KIRKLEES METROPOLITAN COUNCIL INVESTMENT & REGENERATION SERVICE

DELEGATED DECISION TO DETERMINE PLANNING APPLICATIONS

Reference No:	2024/62/90282/W
Site Address:	16, Pembroke Court, Crosland Moor, Huddersfield, HD4 5NB
Description:	Alterations to roof and erection of front and rear dormers
Recommending Officer:	Joanna Rednall

HOUSEHOLDER DELEGATED REPORT

Drawing Title:
Proposed Elevations

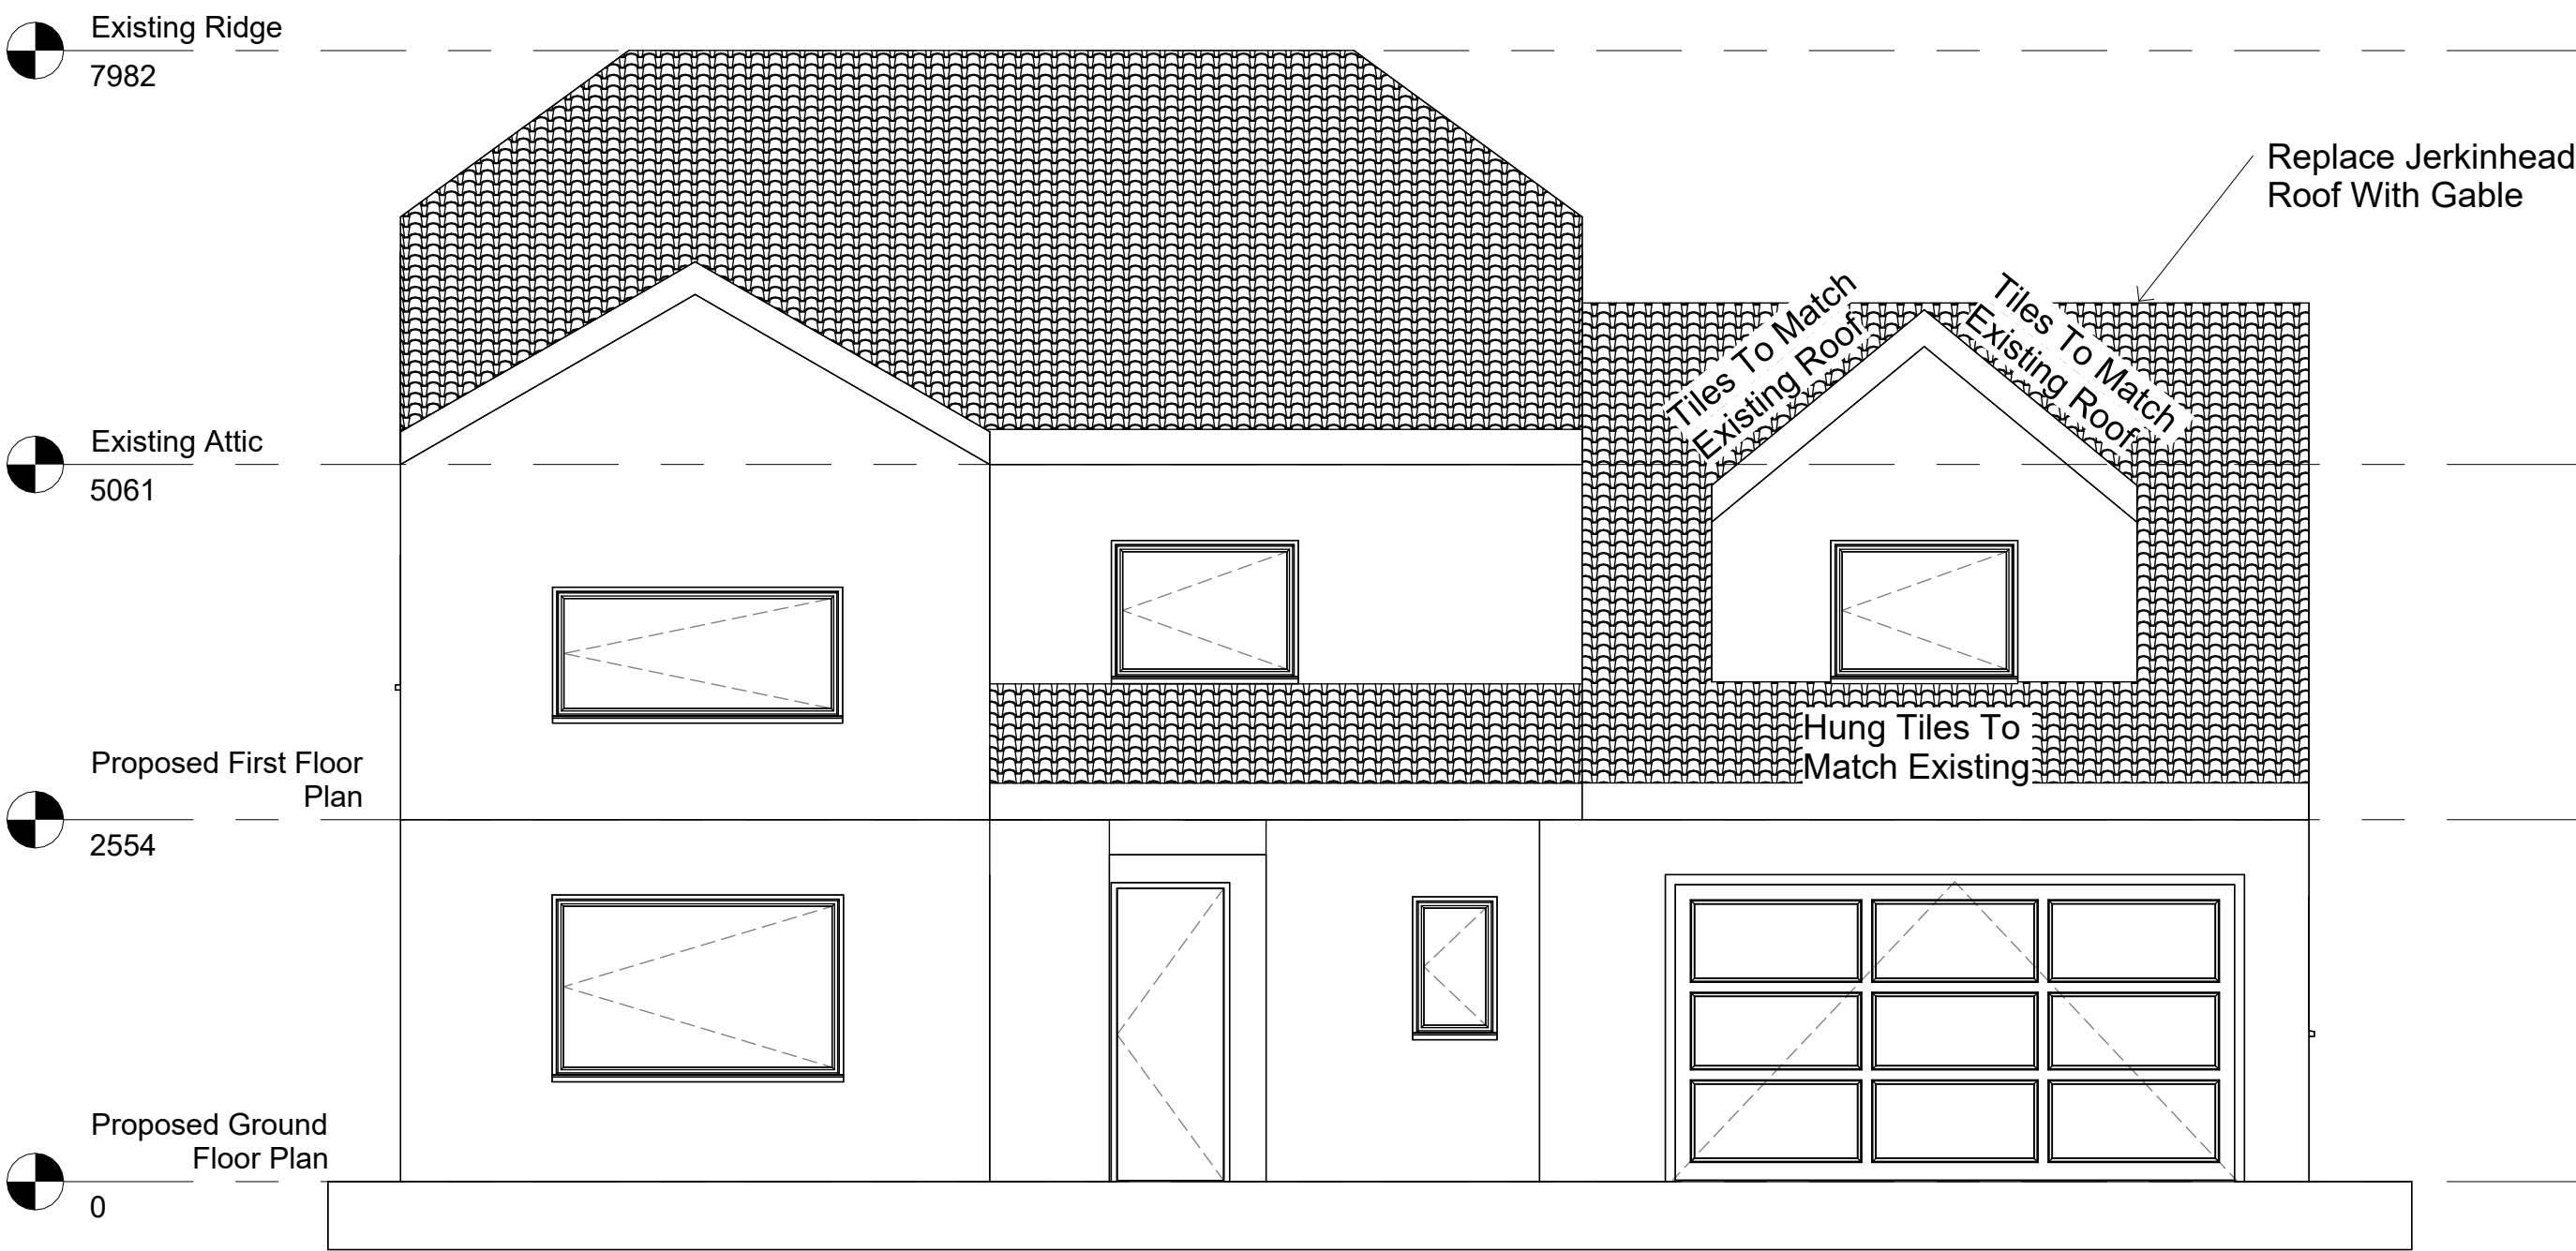
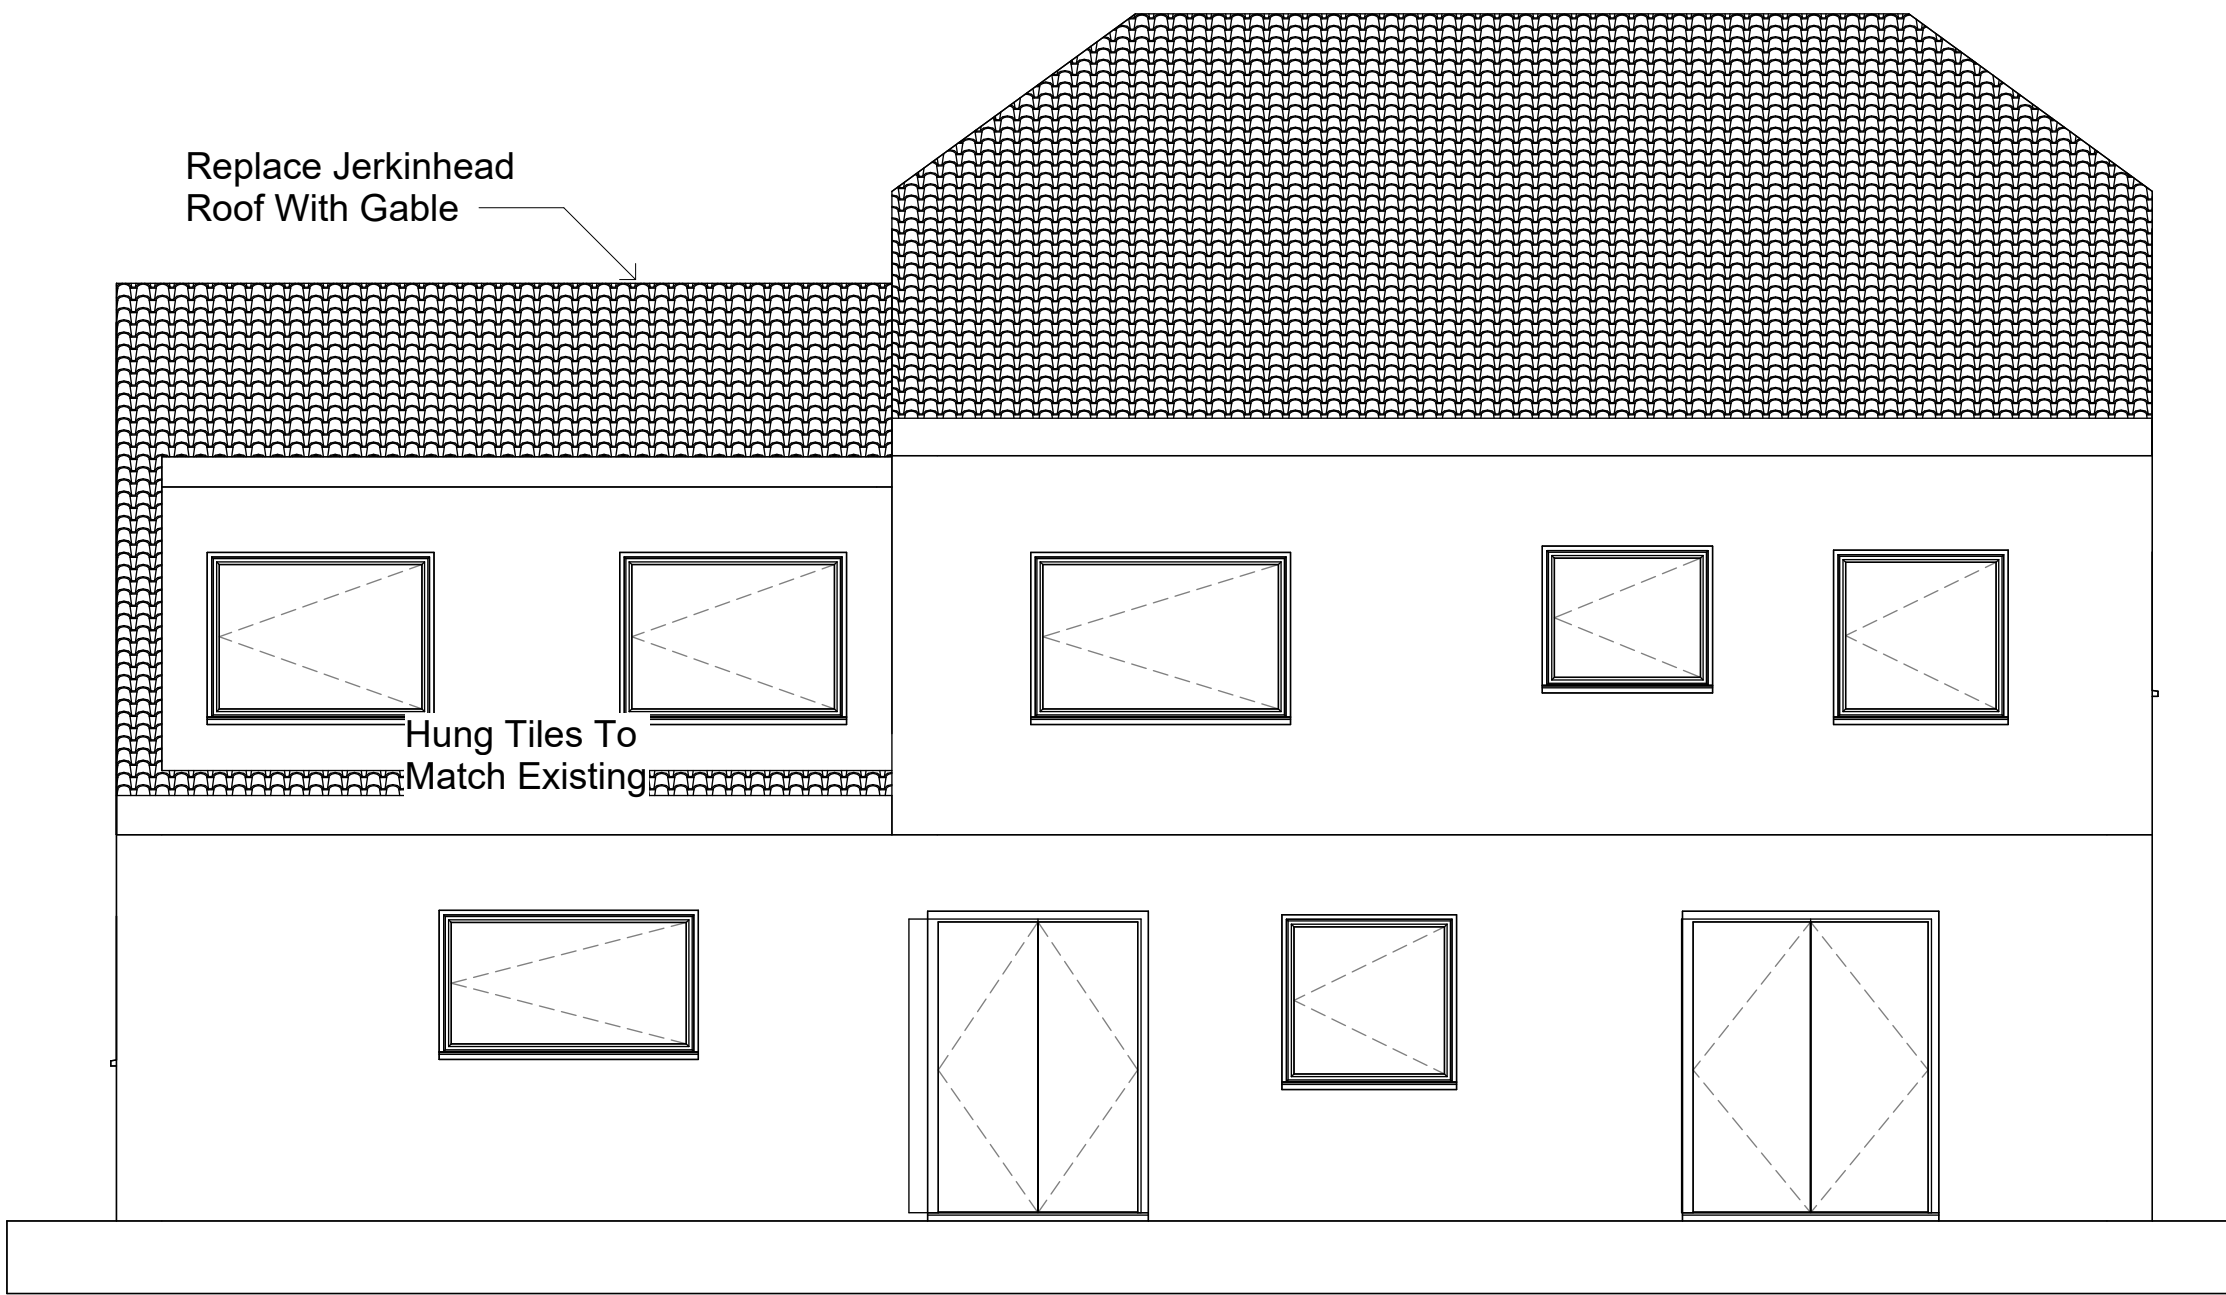
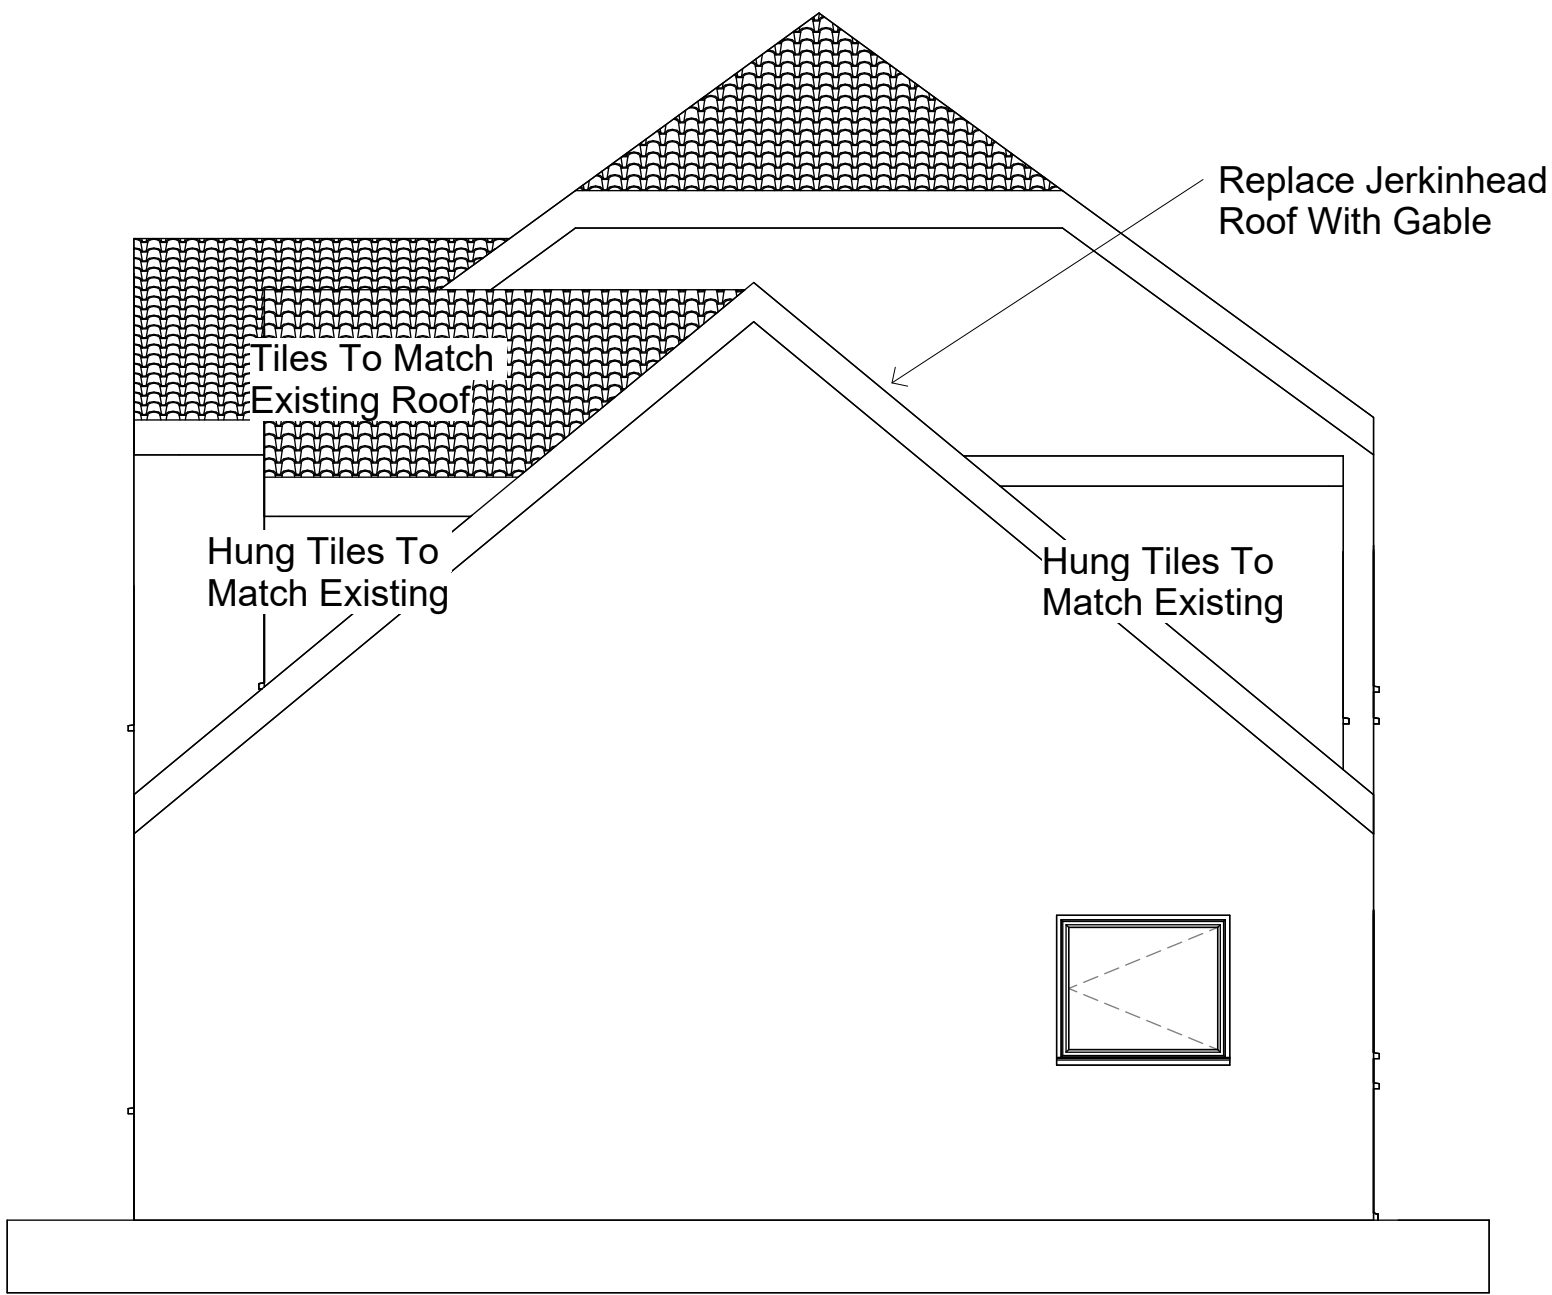
The front dormer is located on the south-west facing elevation. The external walls are constructed from hung tiles with a gable roof. The measurements of the front dormer are as follows:

- ~3 metre width
- ~3.1 metre projection
- ~1.5 metre eave height
- ~2.7 metre total height

The rear dormer is located on the north-east facing elevation. The external walls are constructed from hung tiles with a flat roof. The measurements of the rear dormer are as follows:

- ~4.8 metre width
- ~2.5 metre projection
- ~2.1 metres in height

Dormer extensions should:	<u>Yes - COMPLY</u>	<u>No - JUSTIFY</u>
relate to the appearance of the house and existing roof	Both dormers are set within confines of existing roof.	
be designed in style and materials similar to the appearance of the existing house and roof	Both dormers are faced in hung tiles to match the existing house. Front dormer – gable roof in design to match host dwelling.

not dominate the roof or project above the ridge of the house	The front dormer would not dominate the roof or project above the ridge of the house. Although the rear dormer has a larger width, it is considered that there is sufficient space remaining above the dormer and would not dominate the roof.	
be set below the ridgeline of the existing roof and within the roof plane	Both dormers are set below the ridgeline of the existing roof.	
be aligned with existing dormer windows on neighbouring properties in the same roof plane where relevant	The front dormer has one window and the rear dormer has two windows, all of which will be aligned with existing windows.

• Policy LP24 Design (a) and (c) of the KLP • Chapter 12 NPPF	keeping with the street scene. Following amendments the size of the front dormer is reduced and a sympathetic addition to the street scene. The rear dormer would not adversely impact the streetscene.	
Impact on original house	• KDP2 of the SPD • Policy LP24 Design (c) and (d) of the KLP • Chapter 12 of the NPPF	The dormers are proportionate to the roof and sympathetic to the existing dwelling.	✓
Height, scale and massing	• KDP 1 and 2 of the SPD • Policy LP24 Design (a), (c) and (d) of the KLP • Chapter 12 of the NPPF	Height is acceptable as amended. Neither dormer would project above the ridge of the house.	✓
Facing materials and detailing	• KDP 9 of the SPD • Policy LP24 Design (d) (iii) of the KLP • Chapter 12 of the NPPF	Hung tiles to match existing dwelling considered acceptable.	✓
Roof style	• KDP 1 and 2 of the SPD • Policy LP24 Design (a), (c) and (d) of the KLP • Chapter 12 of the NPPF	Gable roof for front dormer to match existing house. Flat roof for rear dormer typical for rear dormer extensions and reduces overall mass.	✓

YES / NO	SUMMARY
Negotiations/Amendments during course of application	Yes	Negotiations were made with the applicant's agent regarding the size of the front dormer. Amended plans were received 28 th March.
Parish/Town Council comments sought	No
